Appeal Decision

Appeal Ref: APP/R5510/D/25/3360052

51 Weymouth Road, Hayes, Hillingdon UB4 8NG

- The appeal is made under section 78 of the Town and Country Planning Act 1990 (as amended) against a refusal to grant planning permission.
- The appeal is made by Mr. Abid Shabir against the decision of the Council of the London Borough of Hillingdon.
- The application Ref is 14121/APP/2024/2846.
- The development proposed is for the erection of a part two storey, part single storey side extension and single storey rear extension.

Drawing Title  
Proposed Floor Plans & Elevations

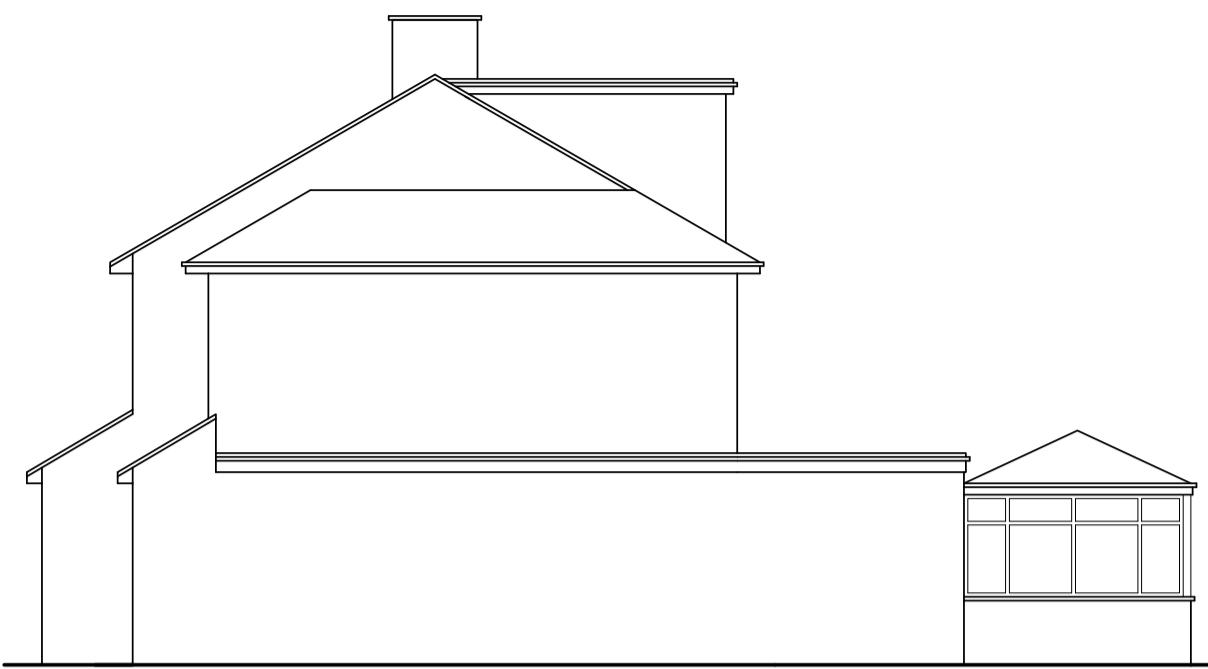
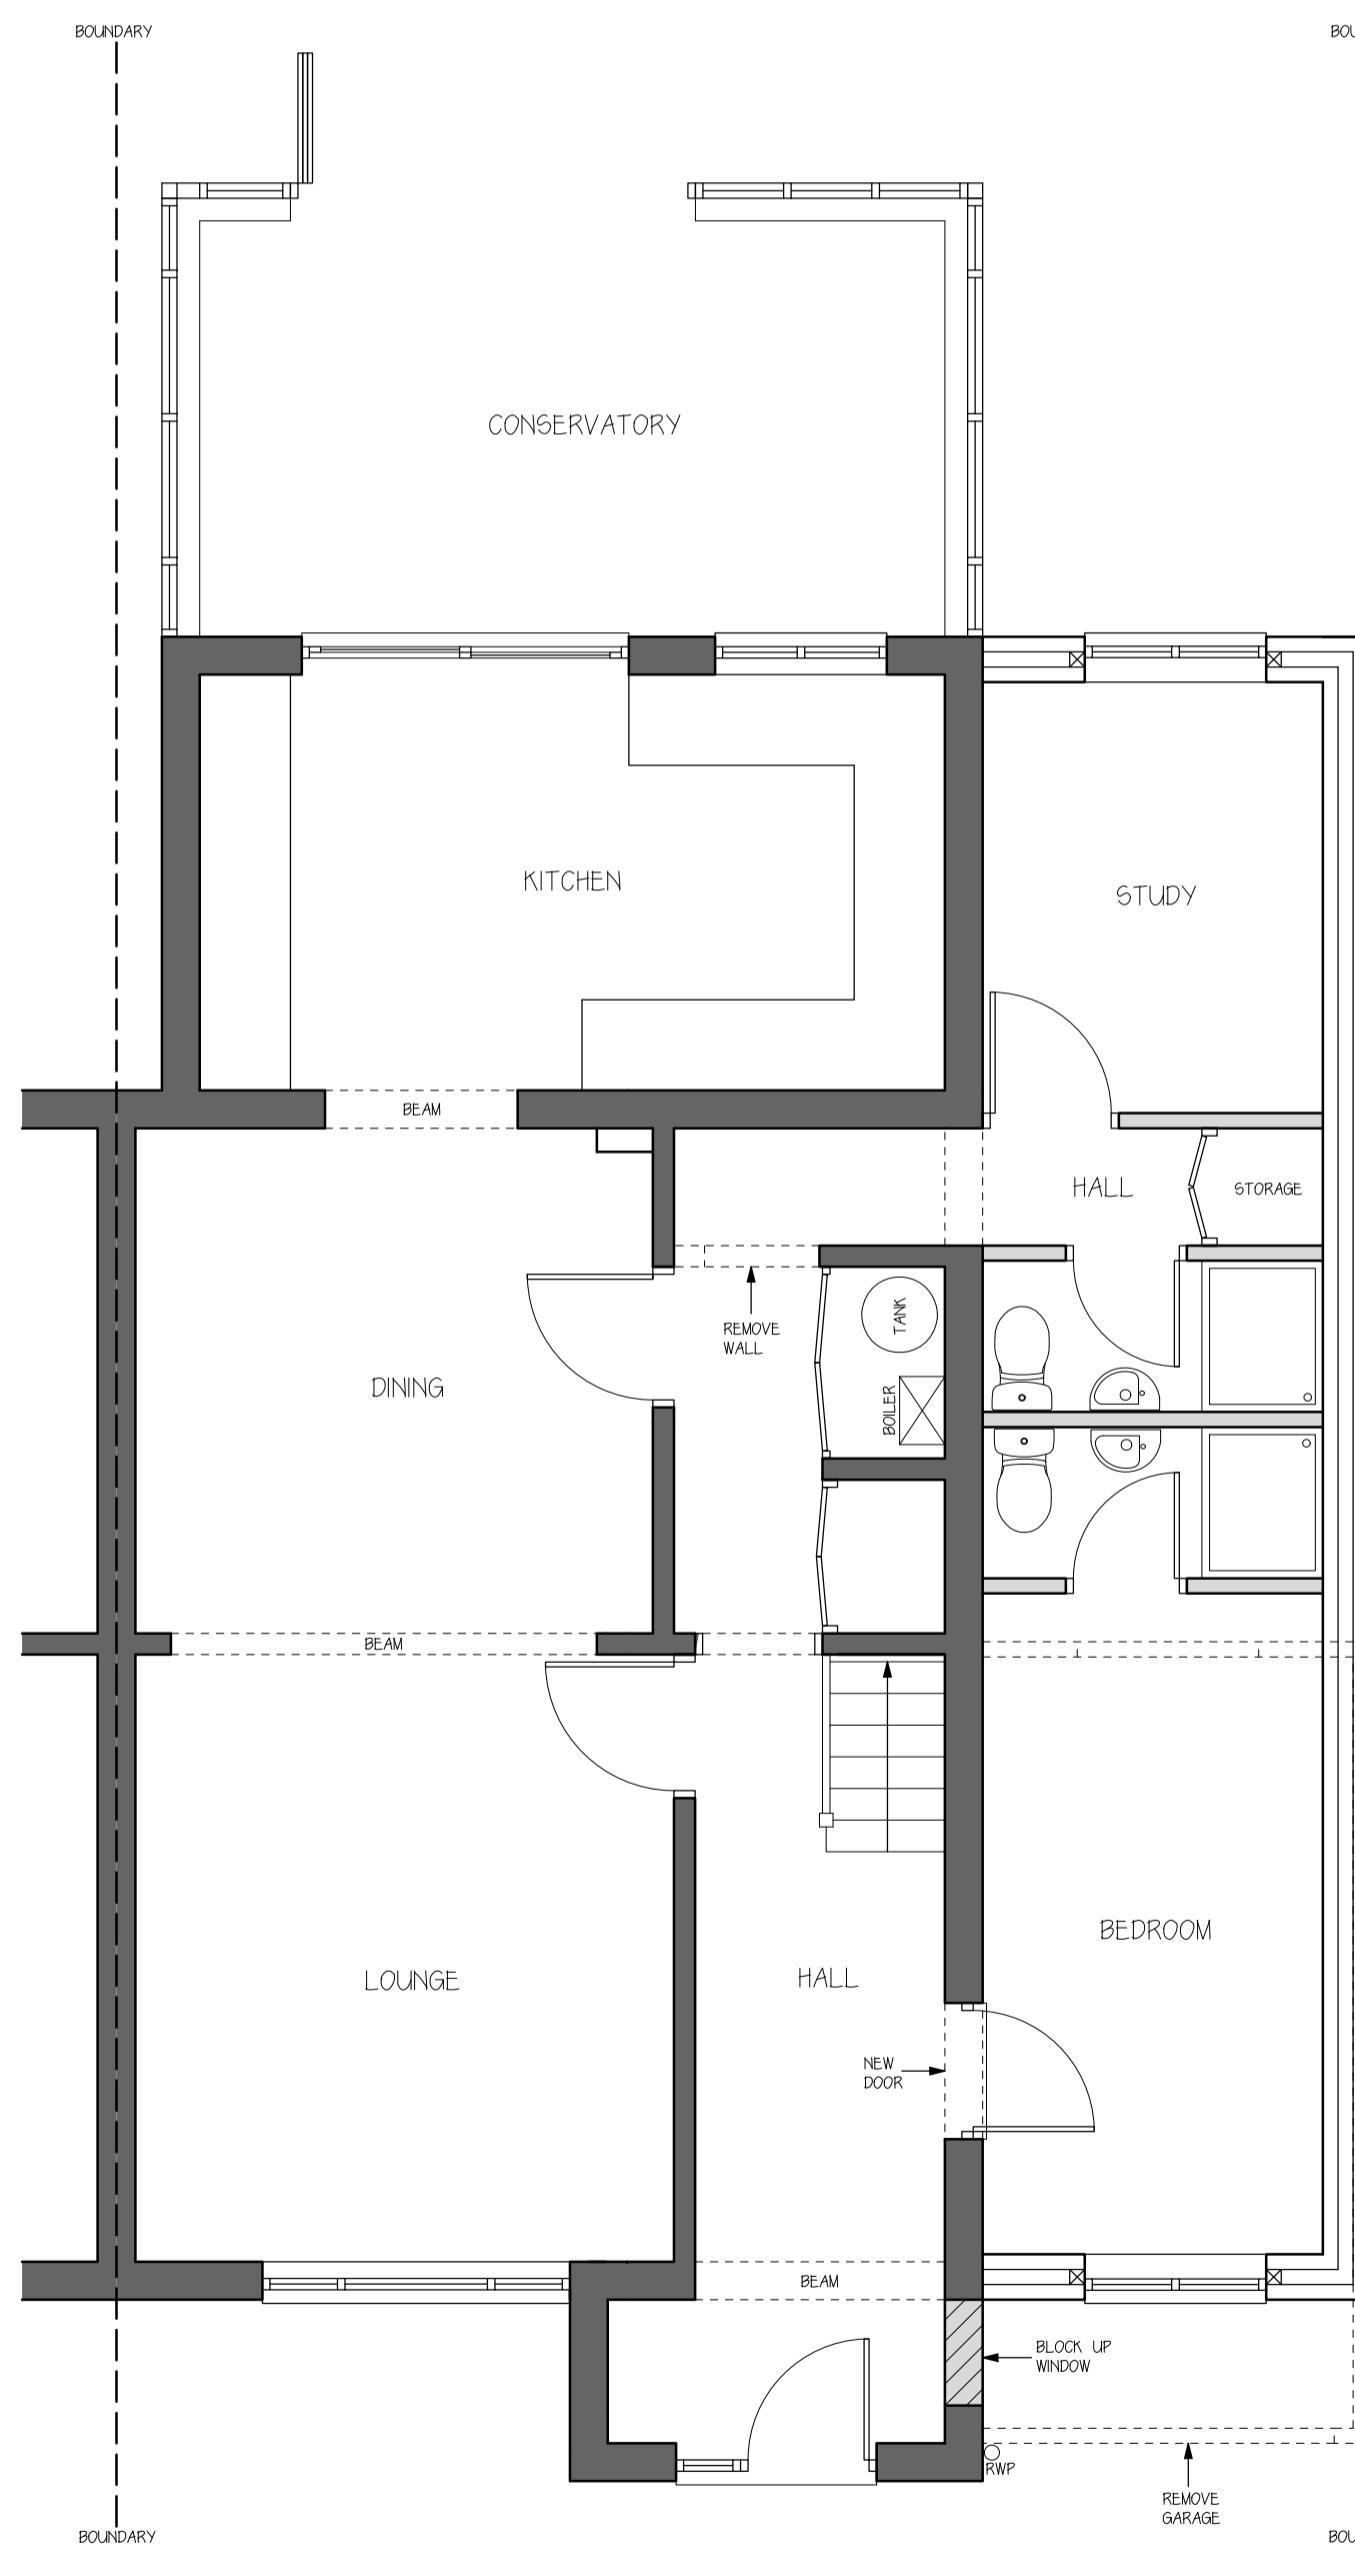
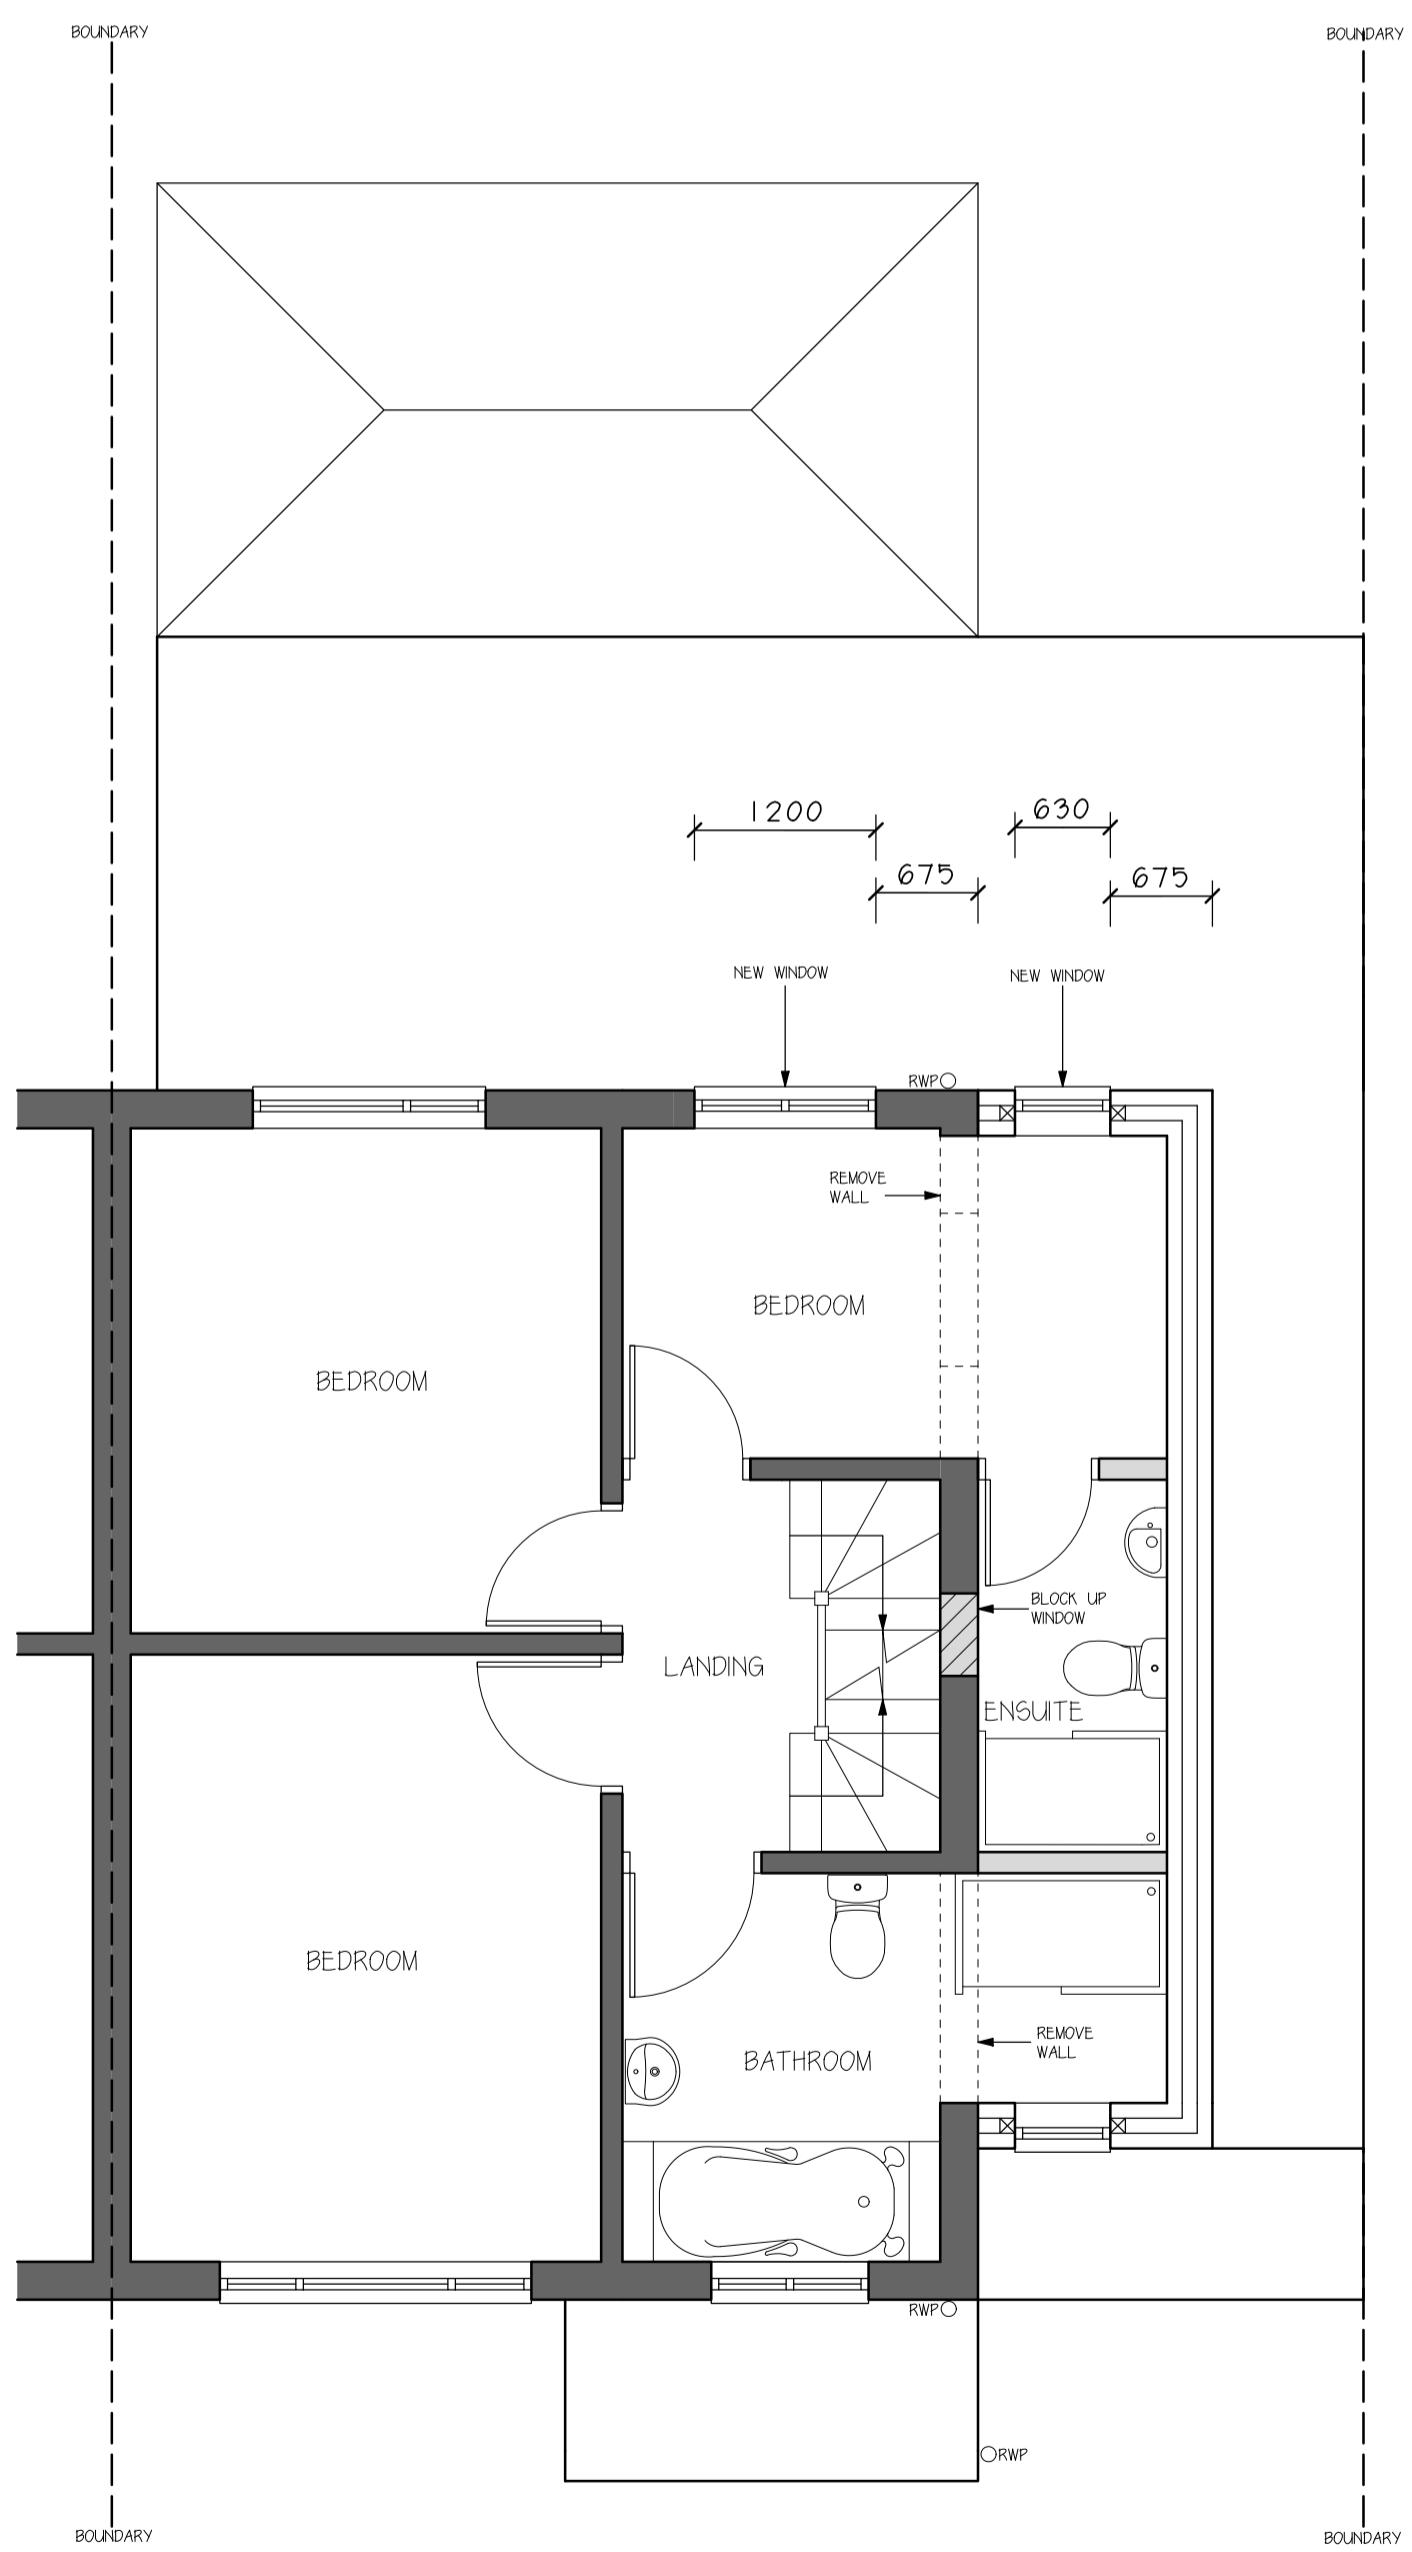
6. The proposal would not provide a one metre setback from the main front elevation and side boundary at ground floor. It also involves a two-storey side extension where a hip to gable roof extension exists. It, therefore, fails to fully comply with Part C) of Policy DMHD 1 under Appendix A of the London Borough of Hillingdon - Local Plan Part 2 2020 (LP P2).

7. Whilst the setbacks at ground floor would not be achieved, this is already the case with the attached garage. The one metre setbacks would also be provided at first floor. These, together with the existing wide gap and the appeal building's positioning, would ensure that the regular rhythm of gaps is maintained along the street scene. Additionally, the proposal will have a slim appearance and would not exceed the width limits of Part C). The ridge height would be well below the main ridgeline with matching eaves. Due to its subordinate size and use of matching materials, it would integrate well with the host dwelling. The proposed hipped roof design would also complement the surrounding original hipped roofs.
